Construction Drawings (PlansProfiles)_v1.pdf Markup Summary

8-29-2022

Cursory comments

INTERSECTION DETAIL

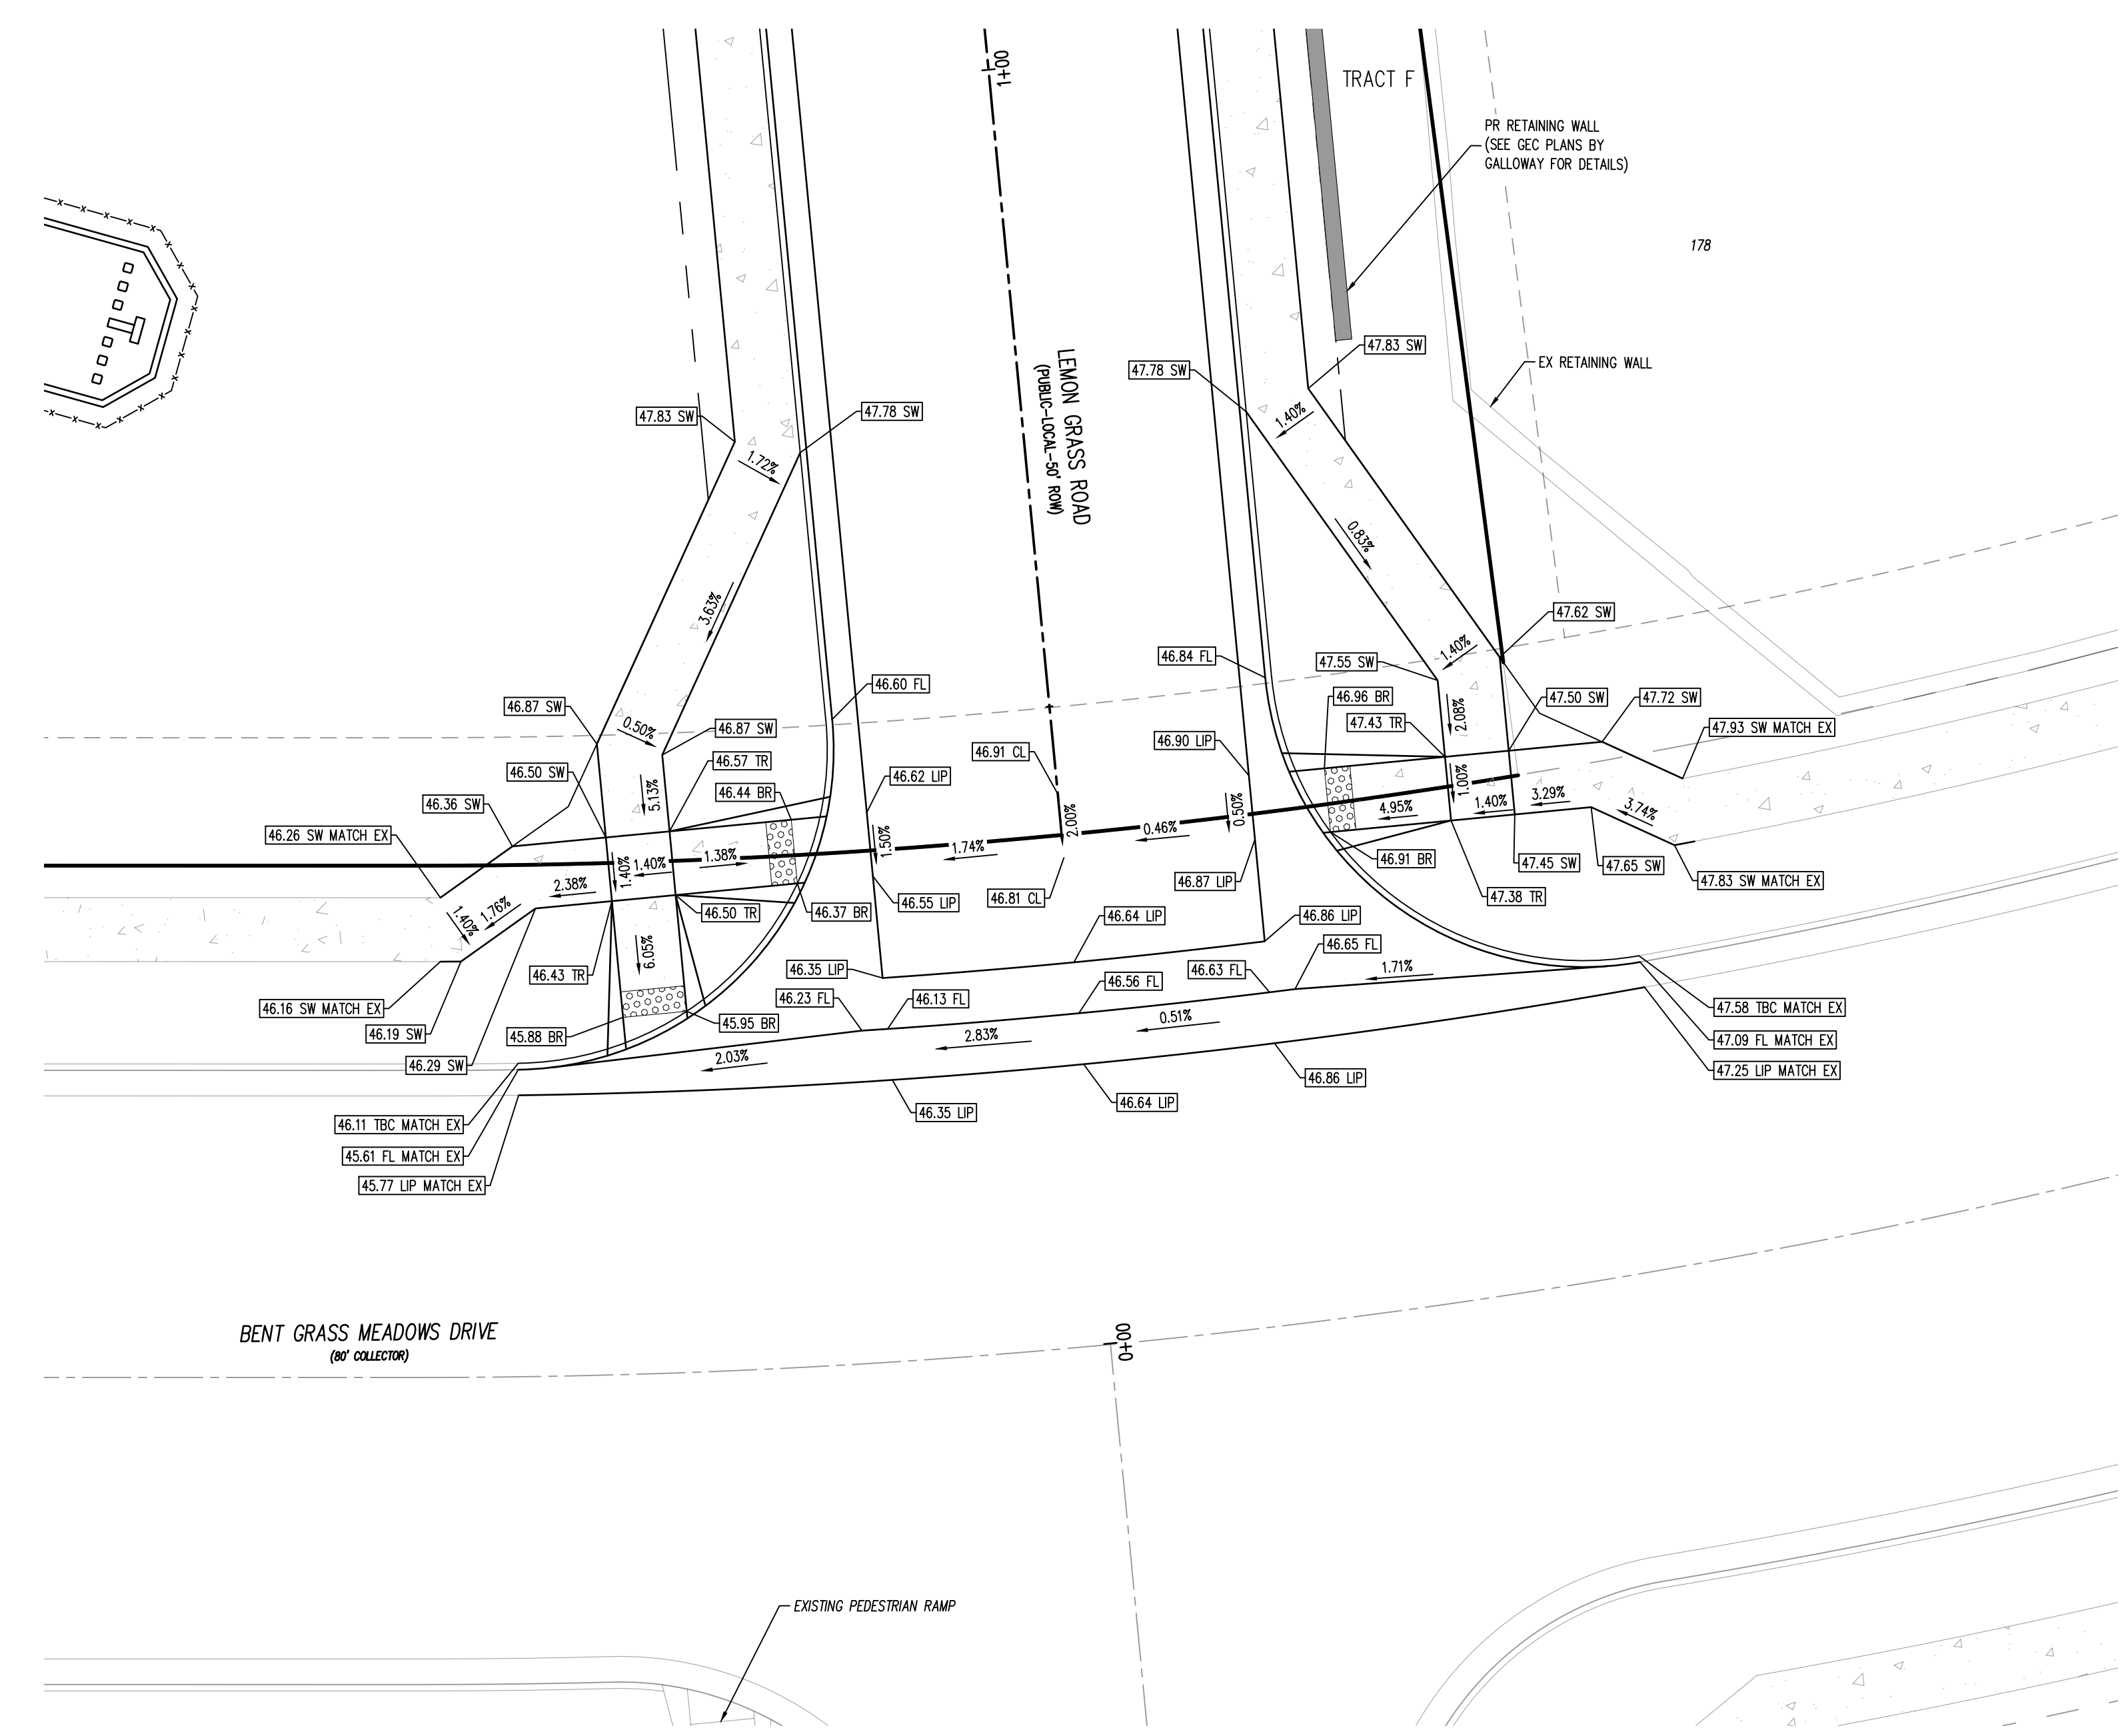
Adjust design per ECM 6.3.1.G

Label existing ramp (if so)

Include signed sheet

Show and label storm drain crossing

**STORM DRAIN PLAN & PROFILE**

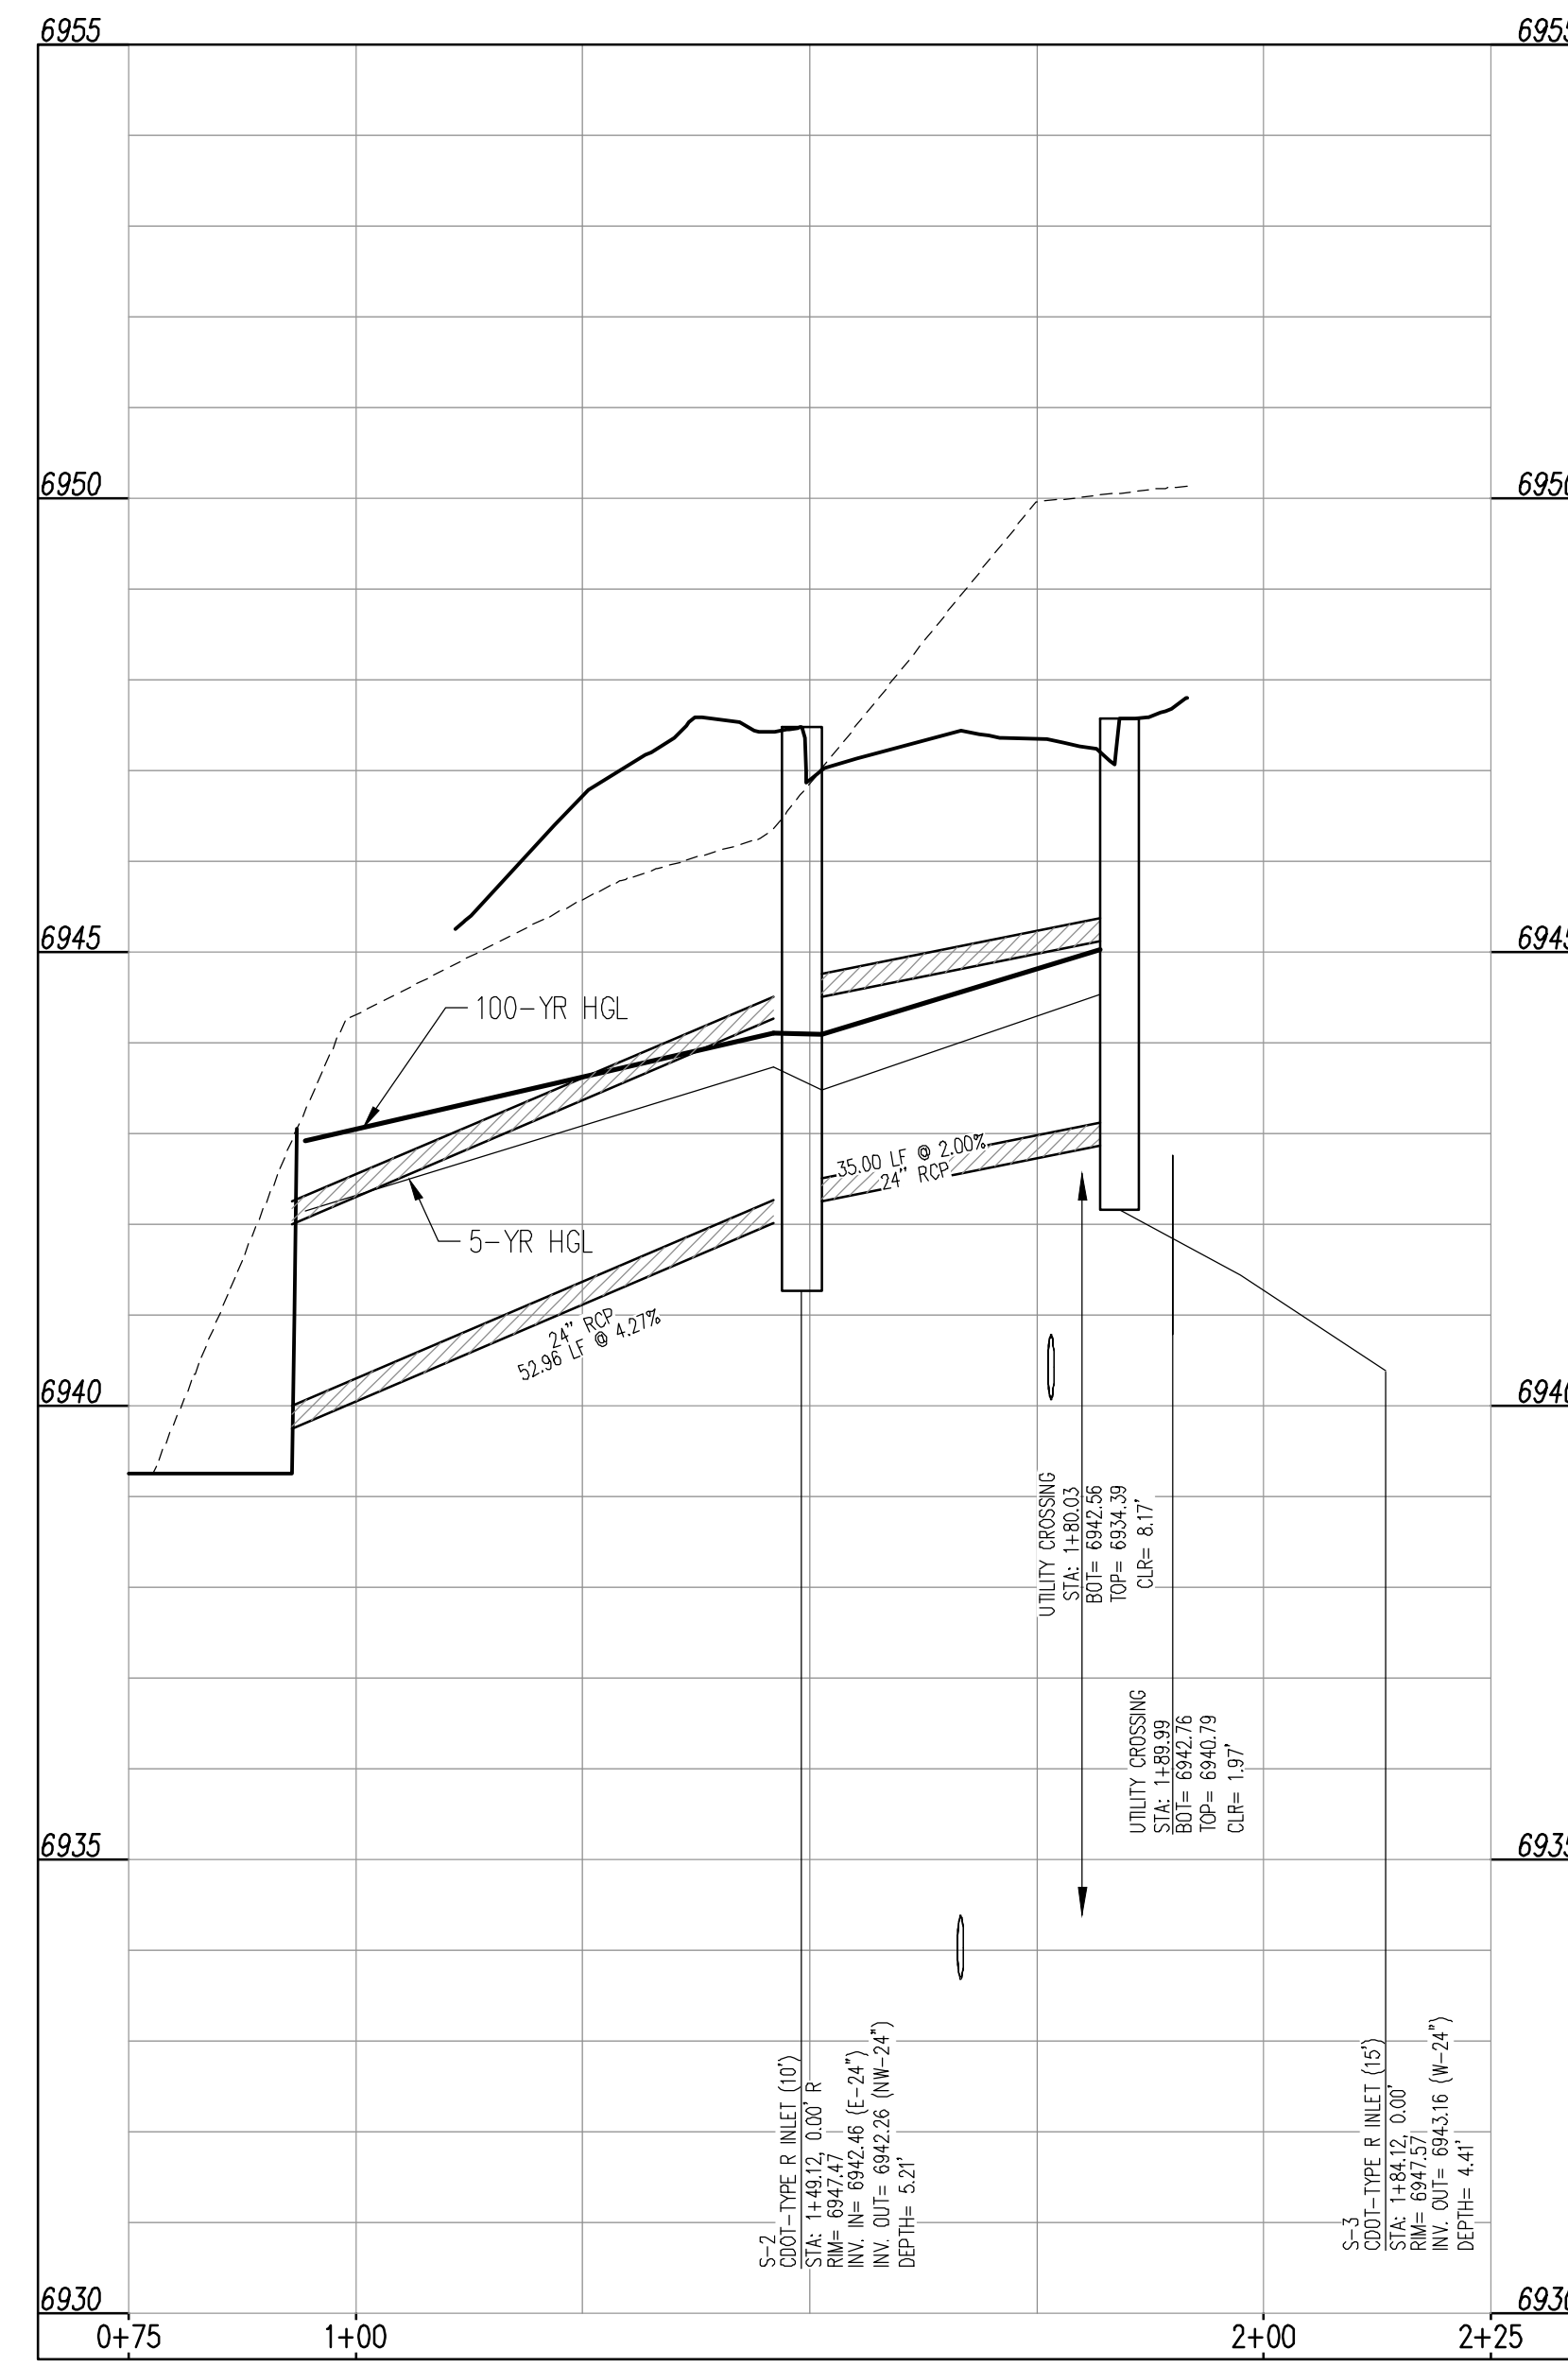
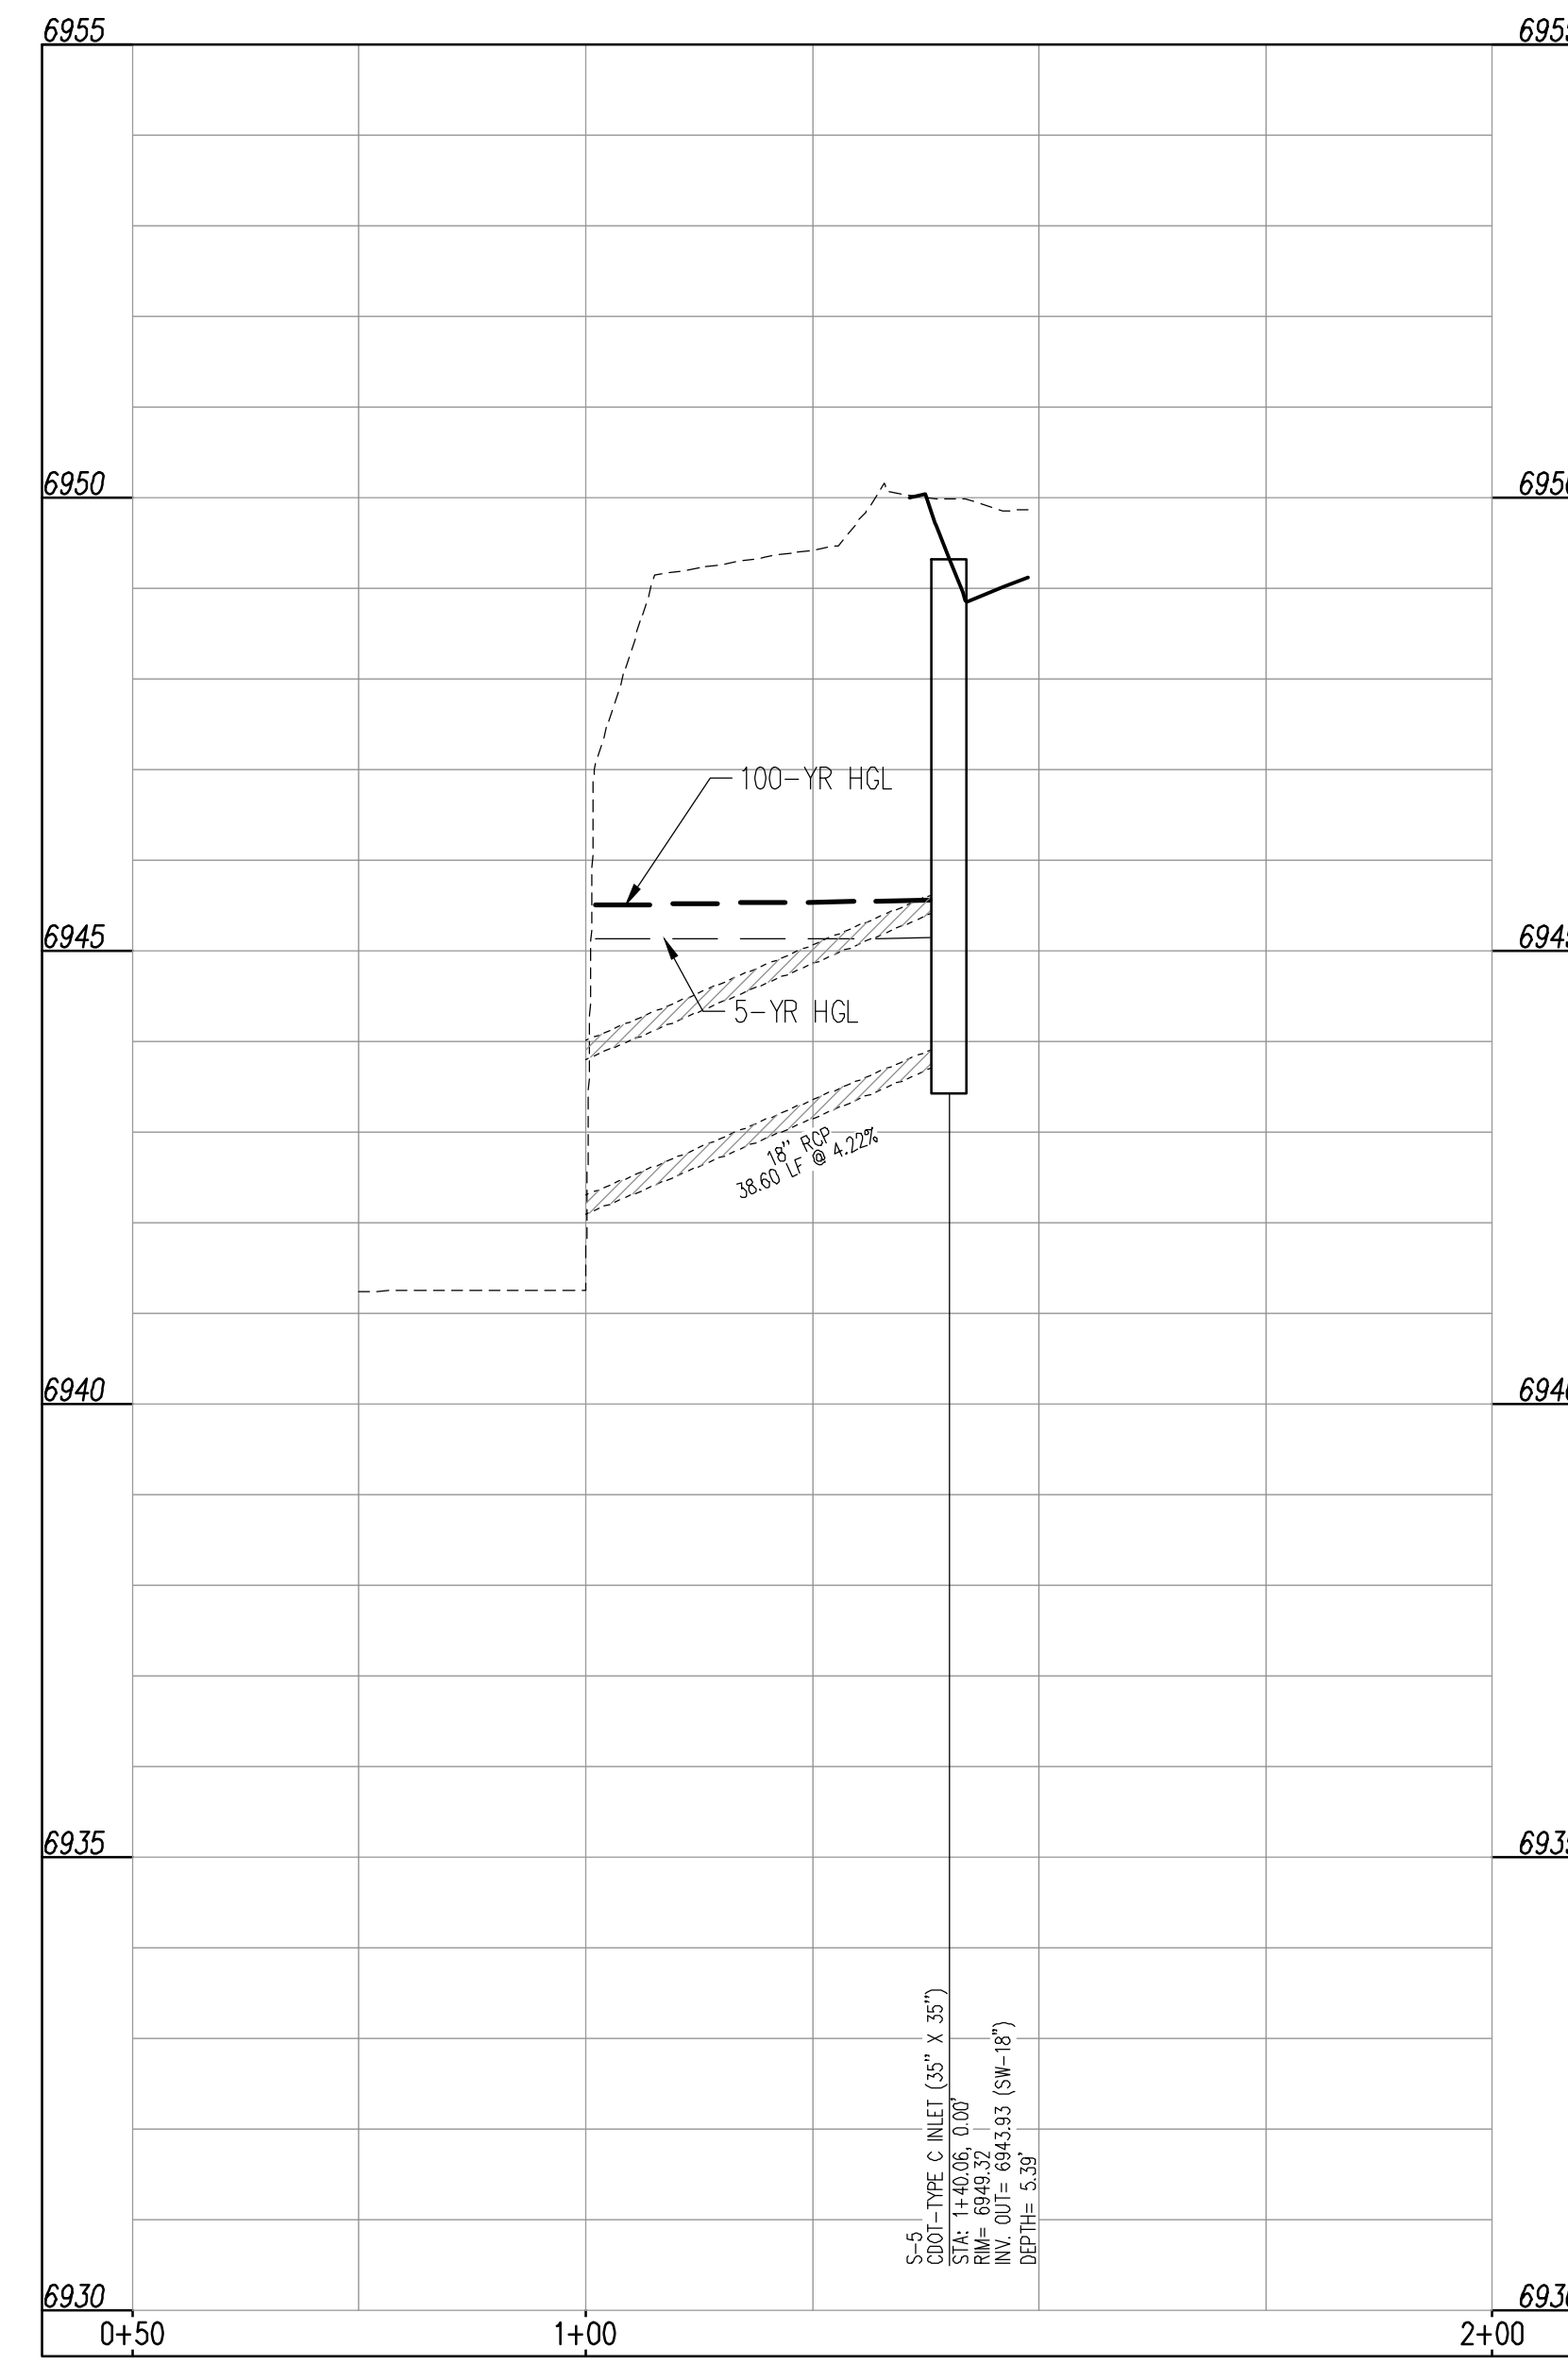
Subject: Callout
Page Label: [8] 8 STORM DRAIN PLAN & PROFILE Show and label HGL and Q5 and Q100
Author: dsdrice
Date: 8/19/2022 1:38:30 PM
Status:
Color: ■
Layer:
Space:

Subject: Callout
Page Label: [8] 8 STORM DRAIN PLAN & PROFILE Show forebay
Author: dsdrice
Date: 8/19/2022 1:39:14 PM
Status:
Color: ■
Layer:
Space:
